CITY OF ALBUQUERQUE

August 10, 2015

**Re: Dreamstyle Warehouse Renaissance Center
Erosion Sediment Control Plan
Engineer's Stamp Date 5-19-15 (F16E051A)**

ENGINEER'S SEAL  RONALD R. BOHANNAN P.E. #7868	TRACT 9A RENAISSANCE CENTER		DRAWN BY BJF
	SEDIMENTATION AND EROSION CONTROL PLAN		DATE 05/11/15
	TIERRA WEST, LLC 5571 MIDWAY PARK PLACE NE ALBUQUERQUE, NM 87109 (505) 858-3100 www.tierrawestllc.com		SHEET # EC-2
			JOB # 2015009

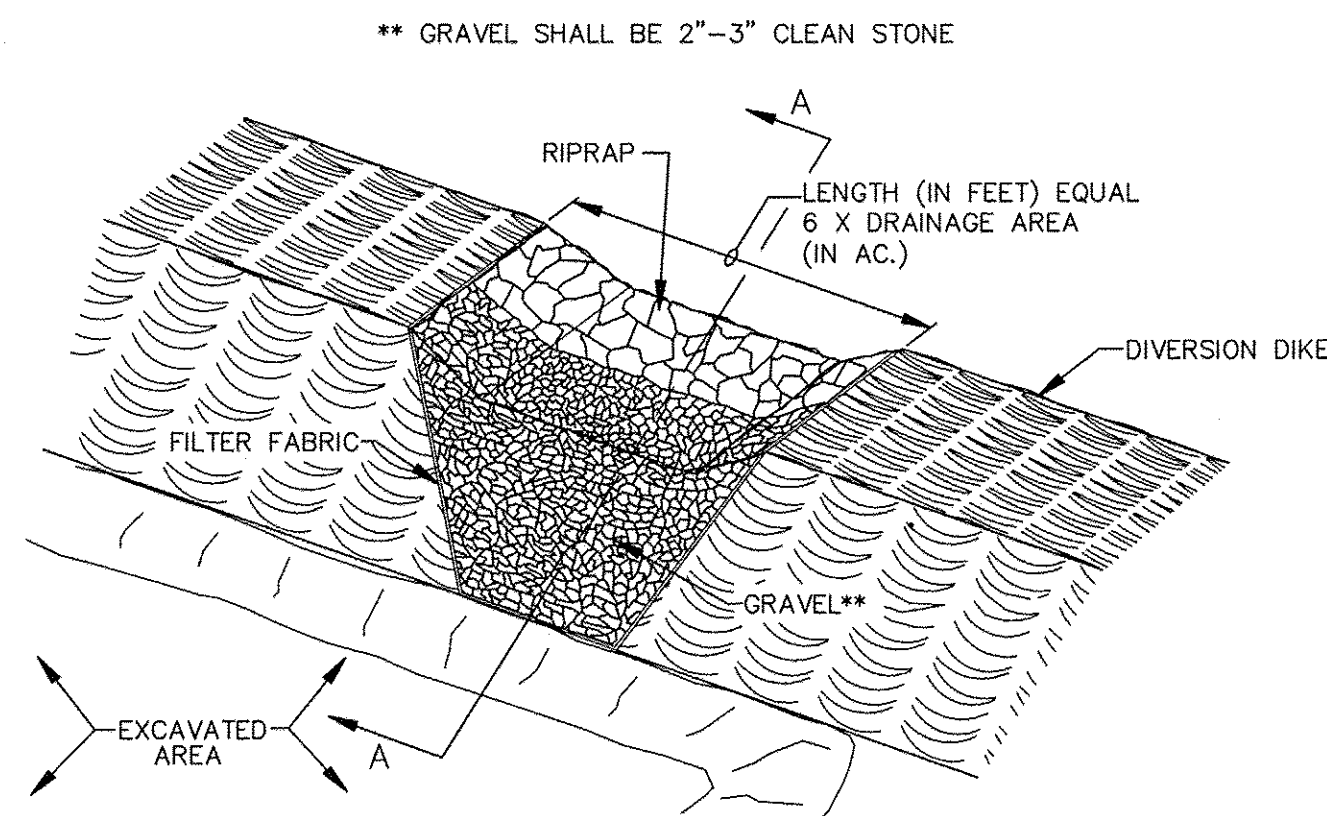
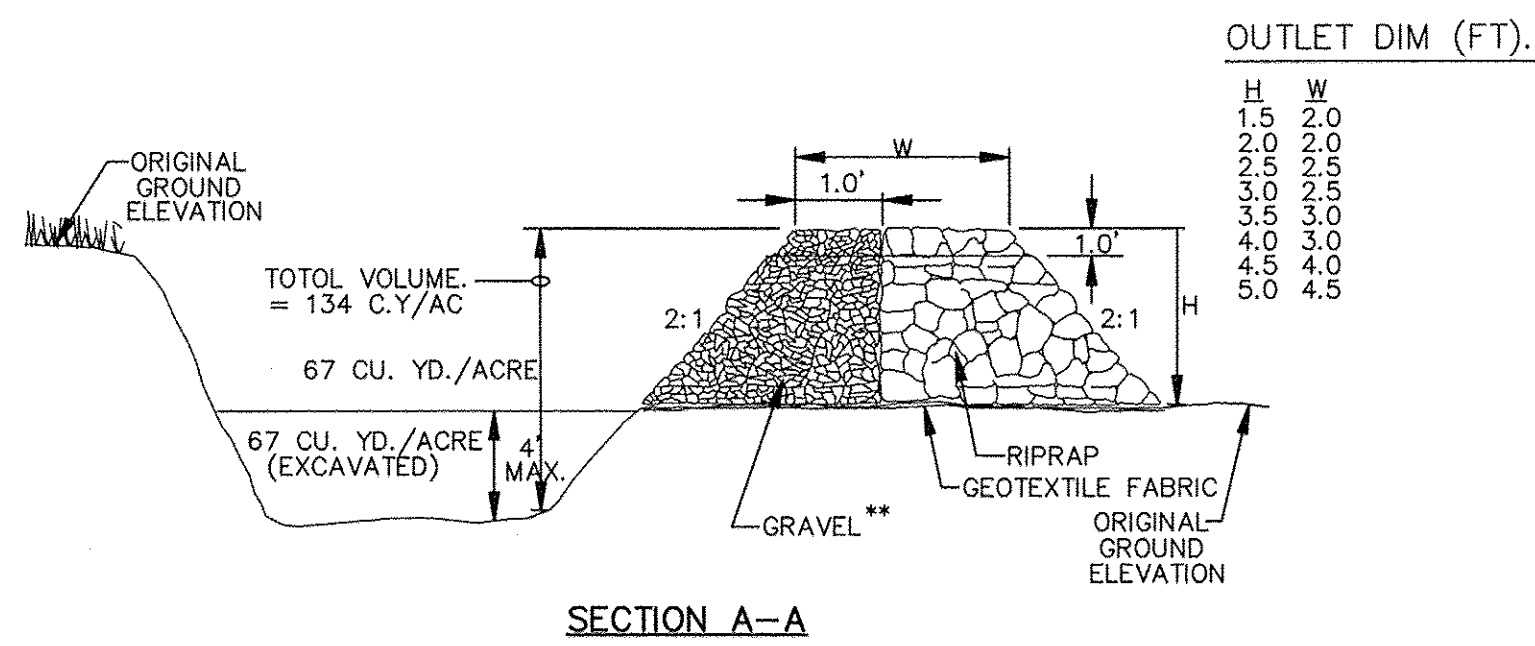
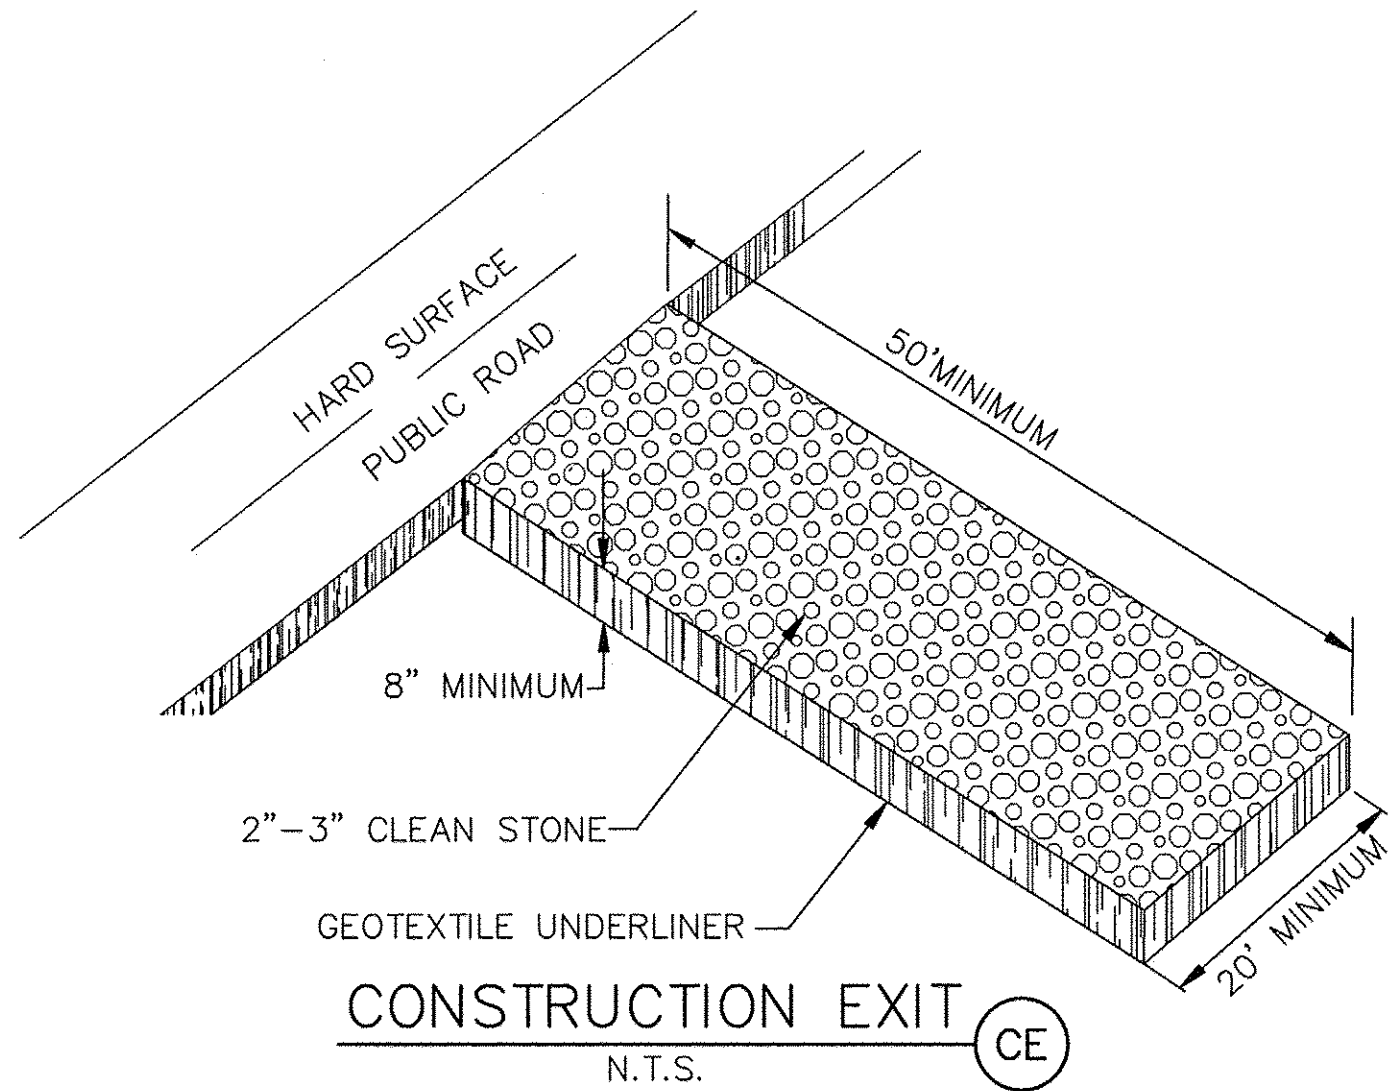
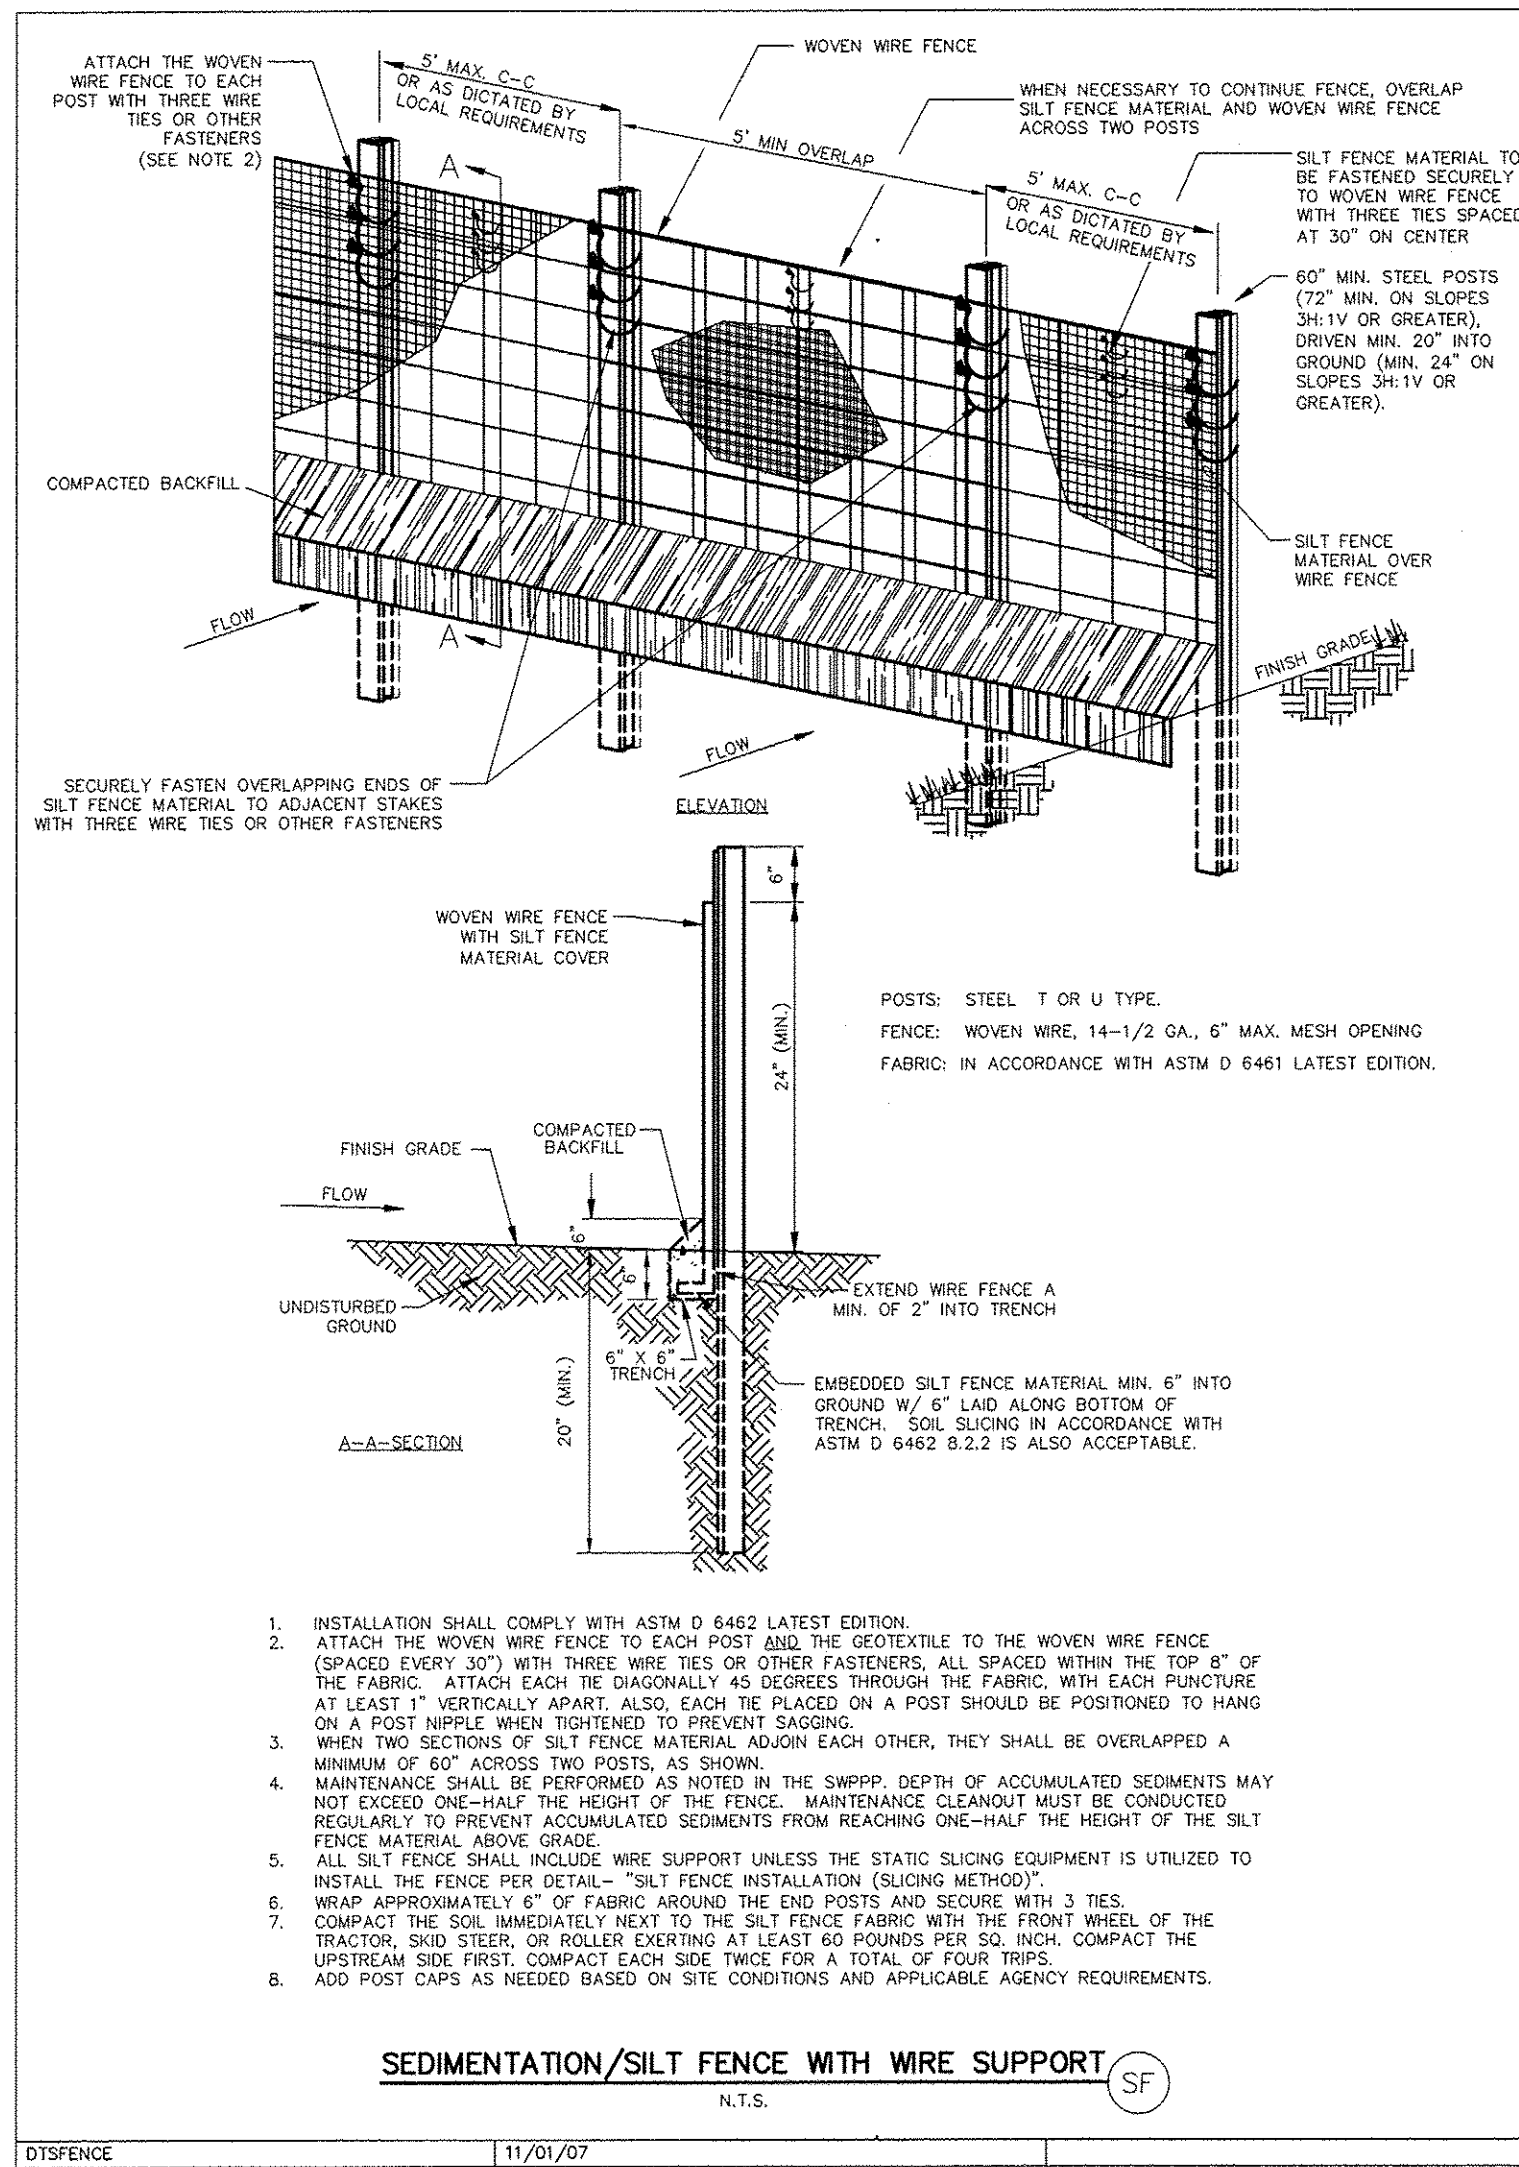
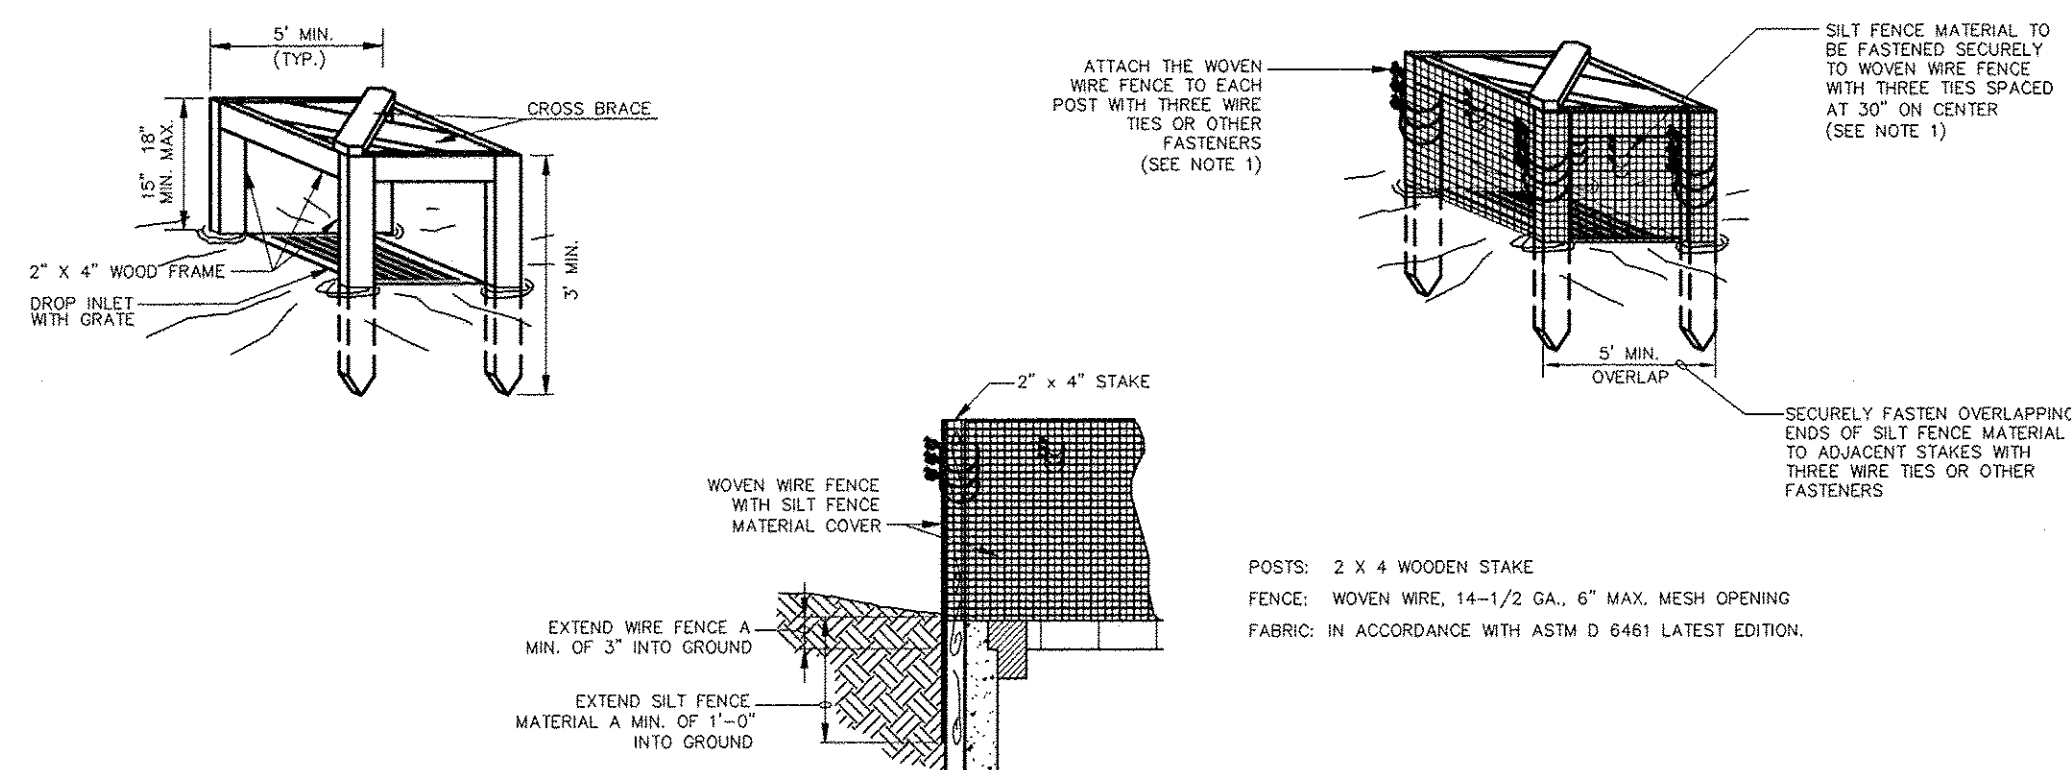
1. Stormwater Quality did not receive a detail sheet with the submittal. Include a detail sheet, similar to other plans you have submitted, in the SWPPP.
